**Re: Mesa del Sol Innovation Park Tracts A1A3, A1A4, A1A5 & A4A
2001 Stieglitz Ave SE, Erosion and Sediment Control Plan
Engineer's Stamp Date 12/4/2021 (R16E100)**

Based upon the information provided in your submittal received 2/19/2021 and the Property owner's NOI received 2/24/2021, the above referenced ESC Plan is conditionally approved for Grading only. However, it can't be approved for Work Order until the following comments are addressed.

BOBBY FOSTER ROAD & UNIVERSITY BLVD
IMPROVEMENTS, PH. I
TEMPORARY SEDIMENT AND EROSION CONTROL DRAWINGS
ALBUQUERQUE, BERNALILLO COUNTY, NM

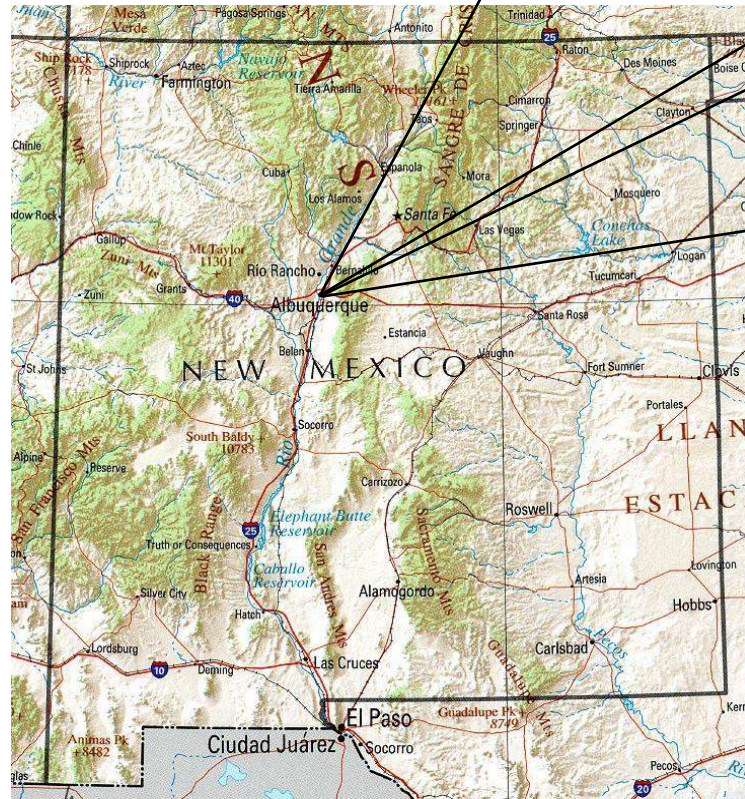
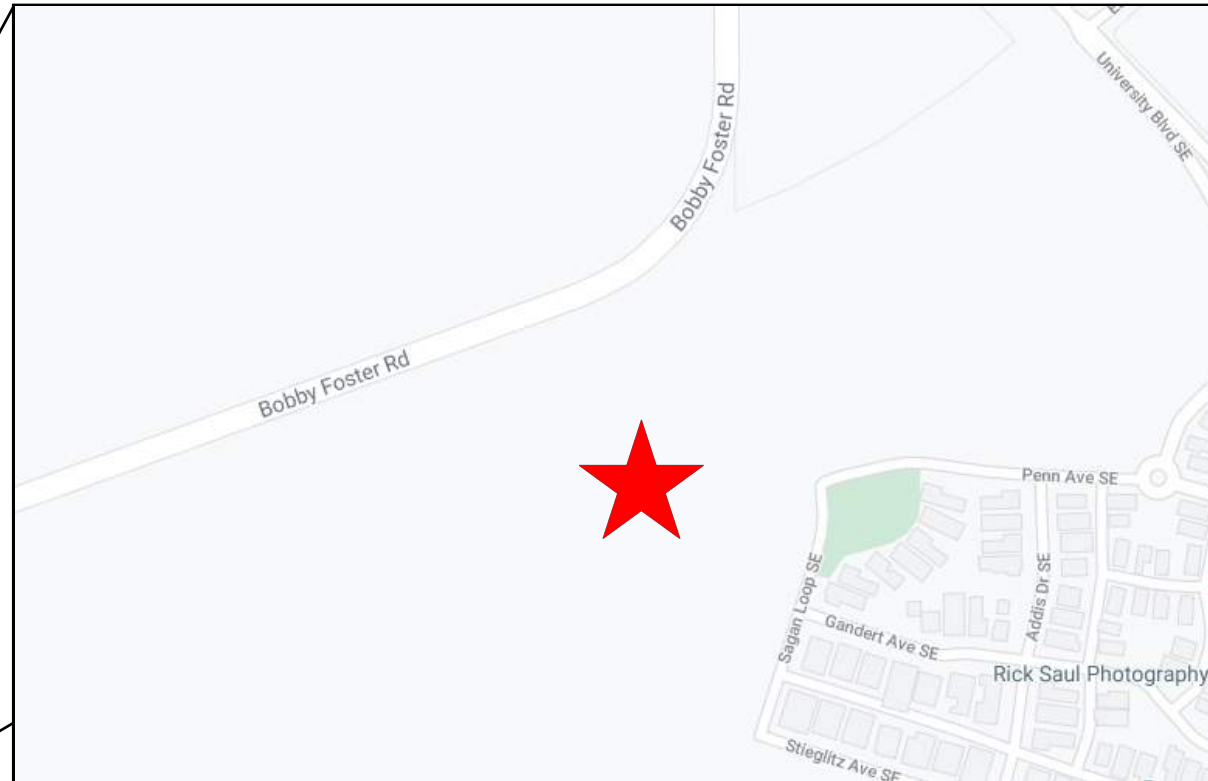
1. The ESC Plan can't be approved until after Hydrology approves the Grading Plan. Grading Plan corrections, if any, must be approved first.
2. The finished grades must be shown on the ESC Plan, and they must agree with the approved Grading Plan. The stockpile areas and limits of Stieglitz paving don't match the approved plan.

3. Revise the limits of disturbance to include all areas of Earth-Disturbing and Construction Support Activities. Add the disturbed area south of the pond. Revise the map as necessary during construction to keep it up to date. Identify the International School site's limits and the operator for that area, The Rachel Mathew Family of Companies (NMR1003KQ). MDS is responsible for the sidewalk and stabilization between the sidewalk and the street.

4. Add silt fence around the site's outside perimeter to comply with the Fugitive Dust Permit and CGP 2.2.3. For areas where perimeter controls are not feasible, include documentation to support this determination and show the other practices that will be implemented to minimize discharges of pollutants in stormwater associated with construction activities.

5. Identify the density of the native cover and expected minimum cover for final stabilization. Also, please identify the soil type and classification.

6. Show additional areas of vegetative stabilization next to roads where applicable. Include all areas of earth-disturbing activities that are not otherwise stabilized with pavement or sidewalks. Paving limits are inaccurate. A strip of vegetative stabilization is missing next to the roads.

7. Indicate the beginning and ending dates of the seasonally dry period and consider modifying the schedule you will follow for initiating and completing vegetative stabilization to correspond to these dates. Perhaps the pond and stockpile areas can be seeded this growing season. Other temporary stabilization may be necessary during seasonably dry months.
 8. Please add a description of the word “Tacifier” as it appears under the two stockpile labels on sheet 7.
 9. Please revised ESC Plan and resubmit along with the information sheet and re-review fee. Please remember to update the engineer’s stamp.
- .
